**KIRKLEES METROPOLITAN COUNCIL
INVESTMENT & REGENERATION SERVICE**

DELEGATED DECISION TO DETERMINE PLANNING APPLICATIONS

Reference No:	2023/62/93230/W
Site Address:	8, Cross Church Street, Paddock, Huddersfield, HD1 4SN
Description:	Erection of single storey rear extension
Recommending Officer:	Tom Hunt

Officer Report

GROUND FLOOR PLAN AS PROPOSED
SCALE 1:50

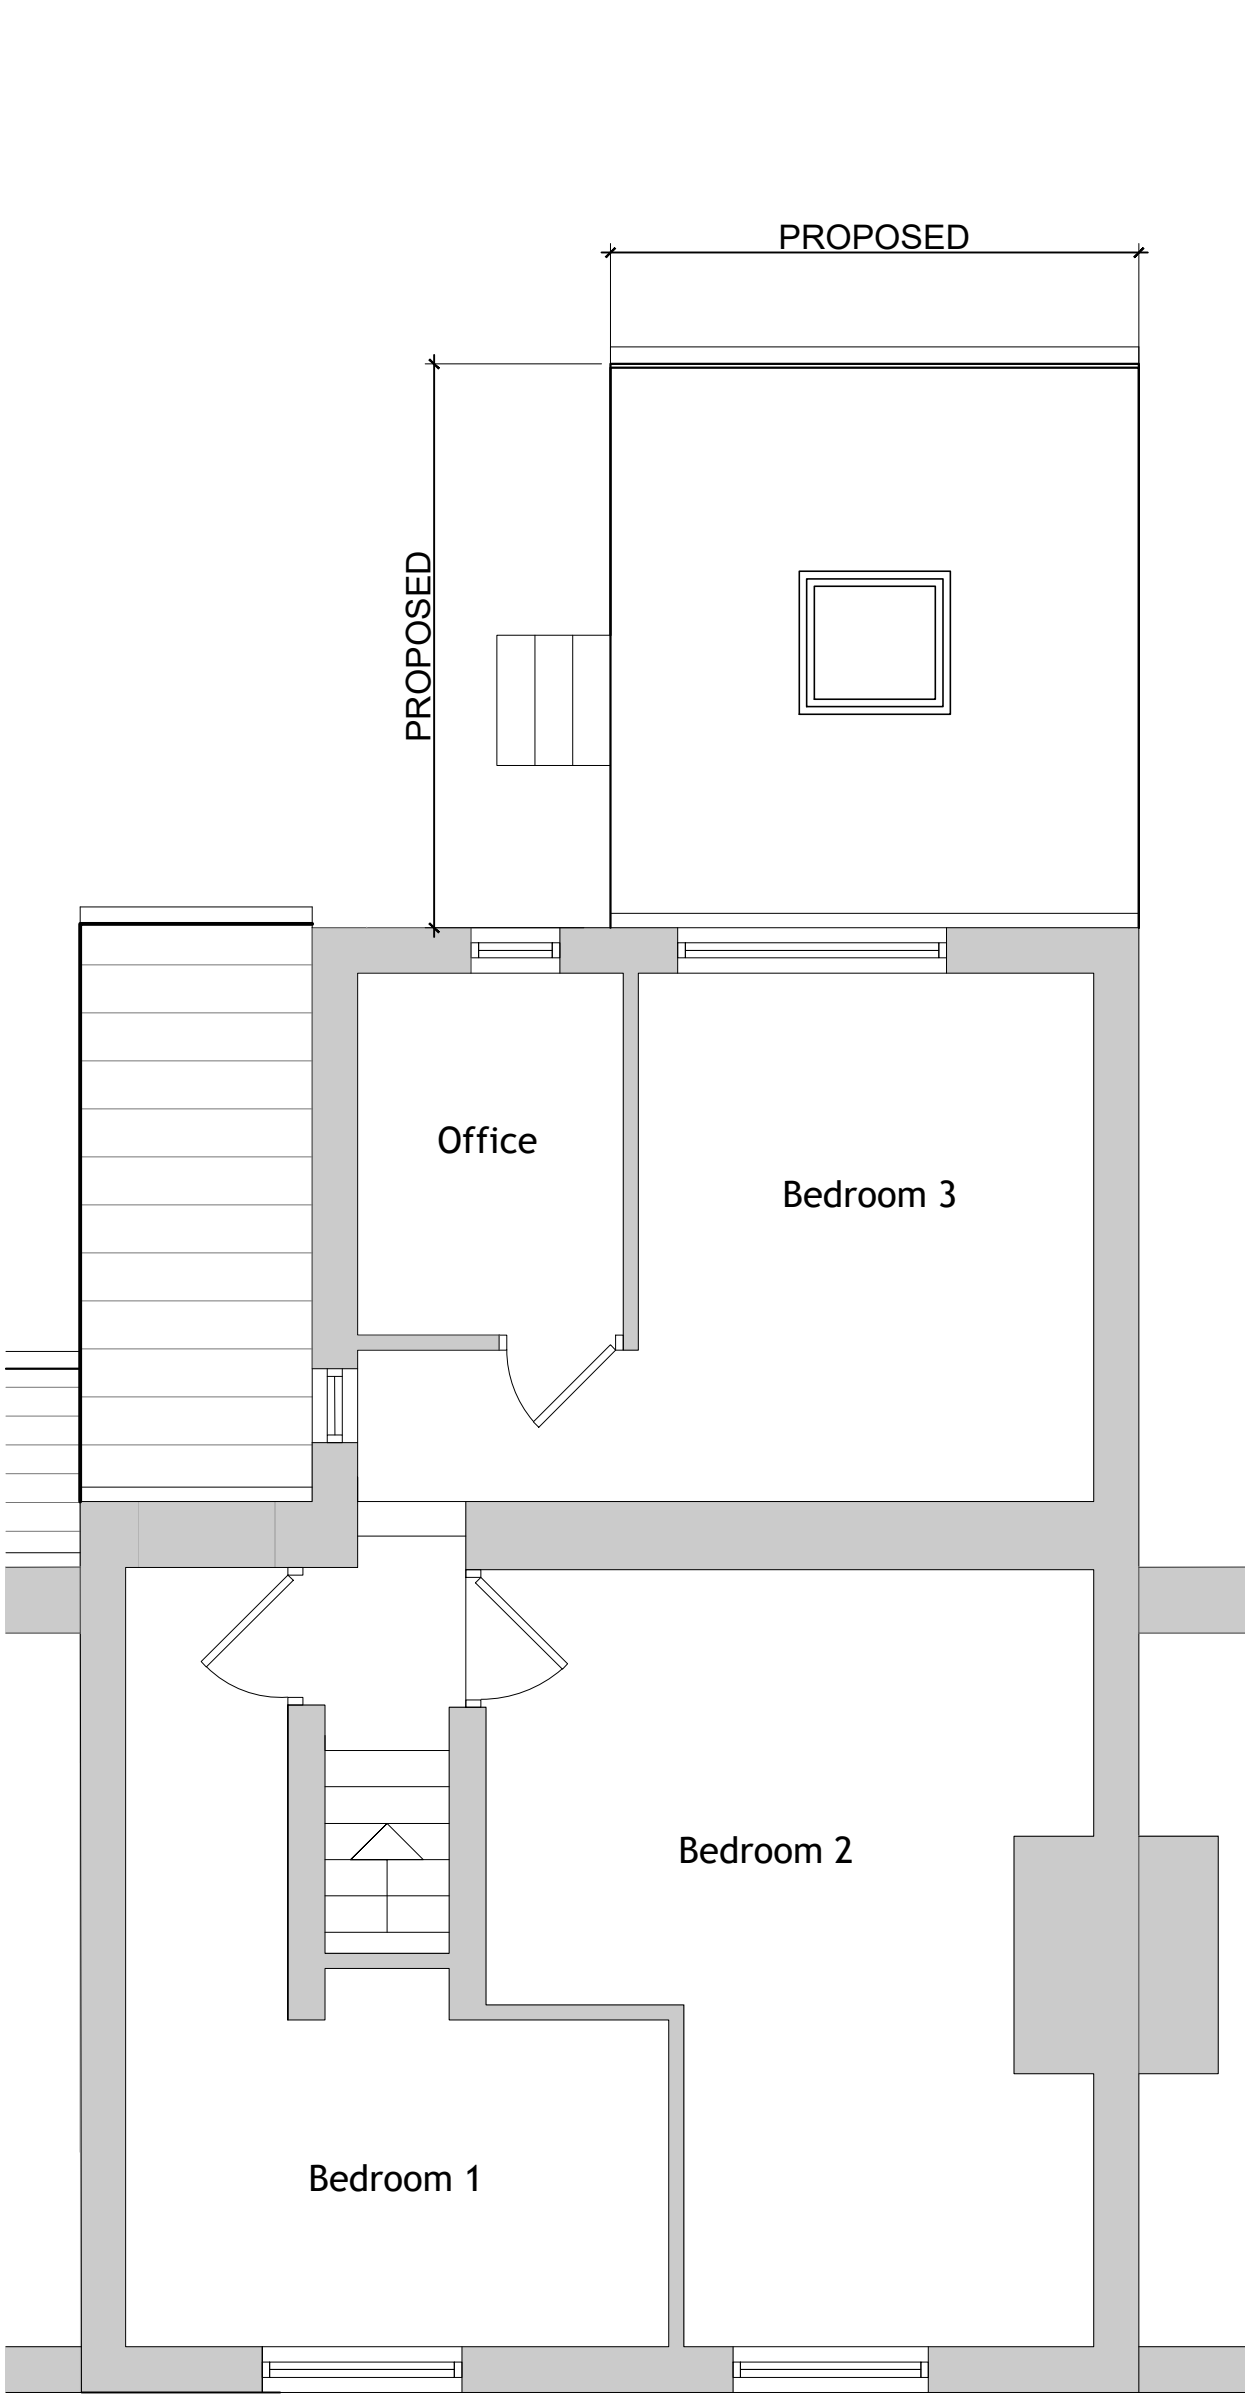
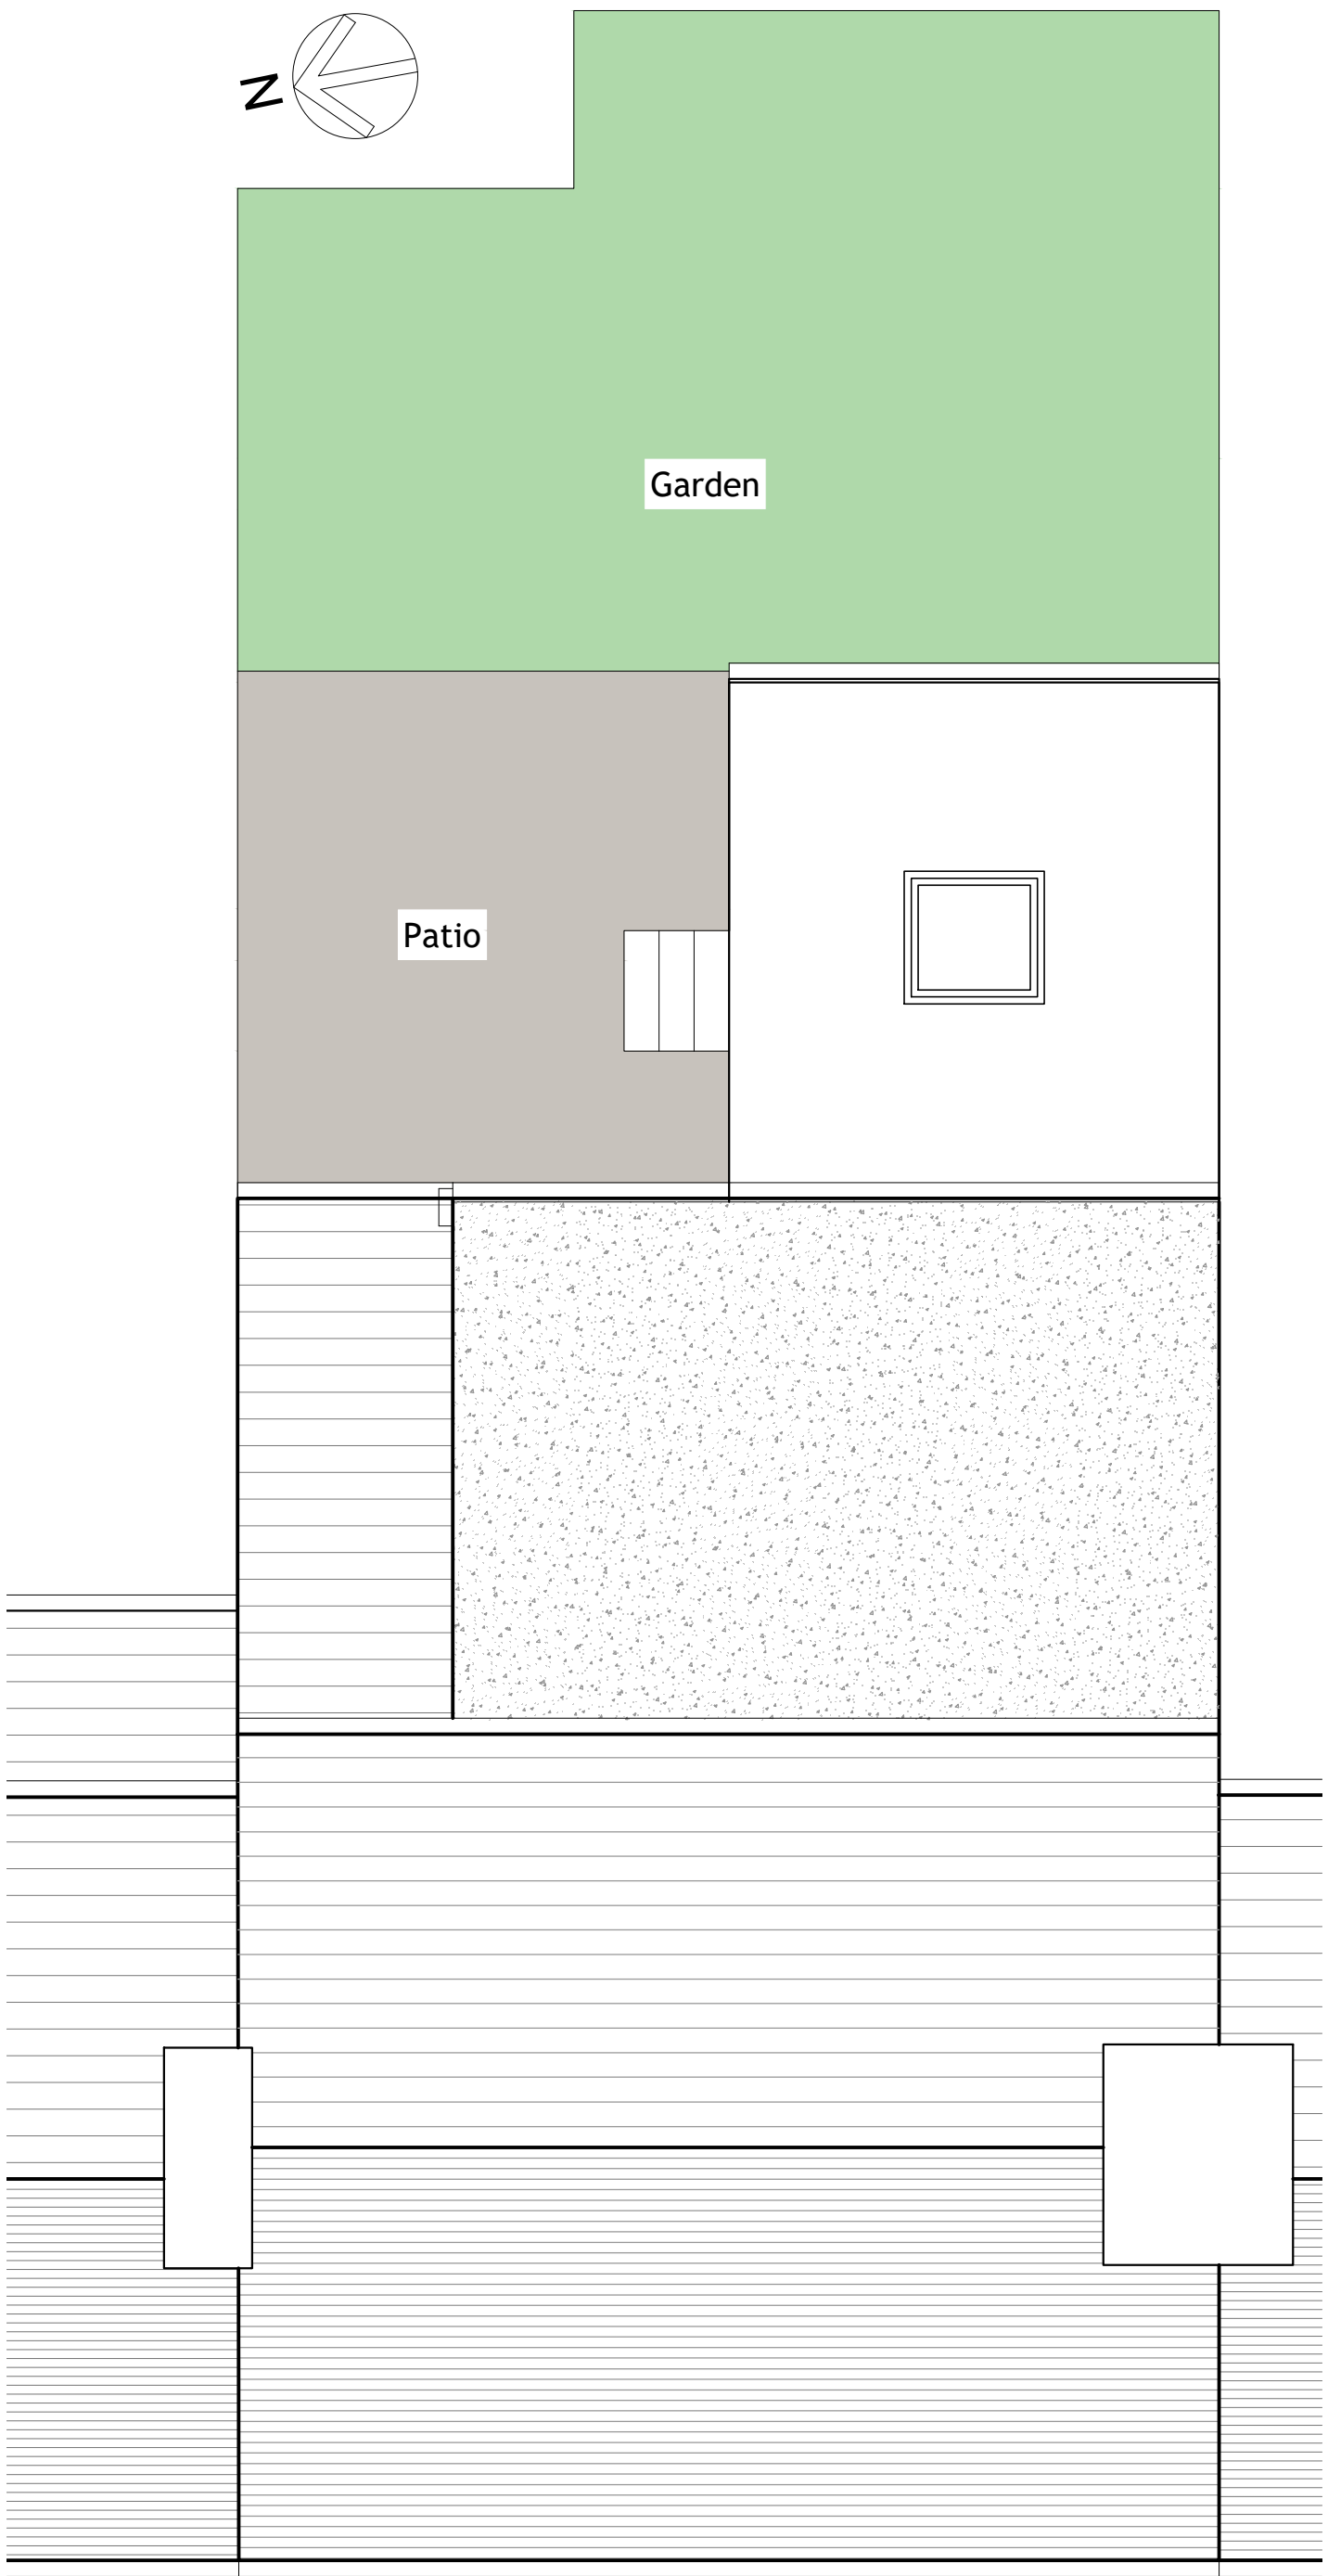
The proposed rear extension would be, at its width, half the span of the host and would project 3.8m from the two-storey rear projection. This would lead to a cumulative projection of ~7.5m from the original rear elevation of the host which would be the same as the previously existing conservatory (which was exempt from enforcement as previously stated in section ‘1.4 Background’). It would be set back 3.5m from the northern boundary and would be 3.5m height from ground level. This is a significant reduction in width from the previous application for a single storey extension ref 2022/94114.

While its proposed 3.5m height would comply with guidance setting the recommended roof height at 4m from ground level, it would exceed the recommended height of eaves however this would be to provide level internal access for its occupants and seeks to minimise its bulk and massing with a flat roof design.

The design would have a property gap to the northeast neighbouring boundary of 3.5m and would not comply with the southwest boundary. Viewing the proposal's dimensions within the limited scale of the plot, a narrower width extension to comply with this would either increase visual impacts and appear as an incongruous feature and would not be practicable for visual amenity or the needs of the occupants. The property gap to boundaries will be additionally assessed within the 'Residential Amenity' section of this report.

The extension subject of this application is to the north of No. 6, set forward of No. 6's own single-storey rear projection by approximately 3.7m and is built up to the shared boundary with an increase in eaves height of 0.5m compared to the previous hipped roof conservatory (since removed). The obscurely glazed high level window facing this neighbour would be 1.9m height from internal ground level and 2.4m height from ground level to the base of the window with associated restricted views; this would lead to improvements in the previous relationship with regard to privacy and overlooking. While the extension would not be able to demonstrate a 45° field of outlook to the rear projection by the extension being closer to the boundary and would overbear modestly, this would be similar to the previous longstanding impact of the conservatory with regard to overbearing. The extension would be to the northeast of the neighbour and would have very restricted impacts on overshadowing. In a finely balanced consideration, consistent with the Inspector's consideration of the impacts on neighbouring properties which did not raise harm as a determining factor, the limited additional overbearing impact is counterbalanced by there being very restricted impact on overshadowing and no harm to privacy or overlooking to this neighbour, as such this would be acceptable.

The proposed extension would have its flank elevation to this neighbour set 3.5m from the shared boundary and have an obscurely glazed panel to its door facing this neighbour. This would be to the south of the neighbour.

The proposal would have the result of built development extending ~7.5m beyond from the original rear elevation of the host which would have its visual impact in terms of overbearing be mitigated by its single-storey construction and set back from the boundary sufficiently meeting the 45° field of outlook as recommended in KDP 5 of the House Extensions and Alterations SPD. There would be no material loss of privacy to this neighbour.

The benefits of obscure glazing in further reducing loss of privacy to the neighbours is noted in the report and explicitly stated within the submitted drawing 'Location, Site, Proposed Floor, Roof and Elevation Plans. Drawing no. (100) 02. Revision: D' (received 12/01/2024). As such, the plans would be subject to condition two of the Decision Notice, and would not be required to be conditioned separately for residential amenity in accordance with advice set out in the Planning Practice Guidance on 'Use of planning conditions'.
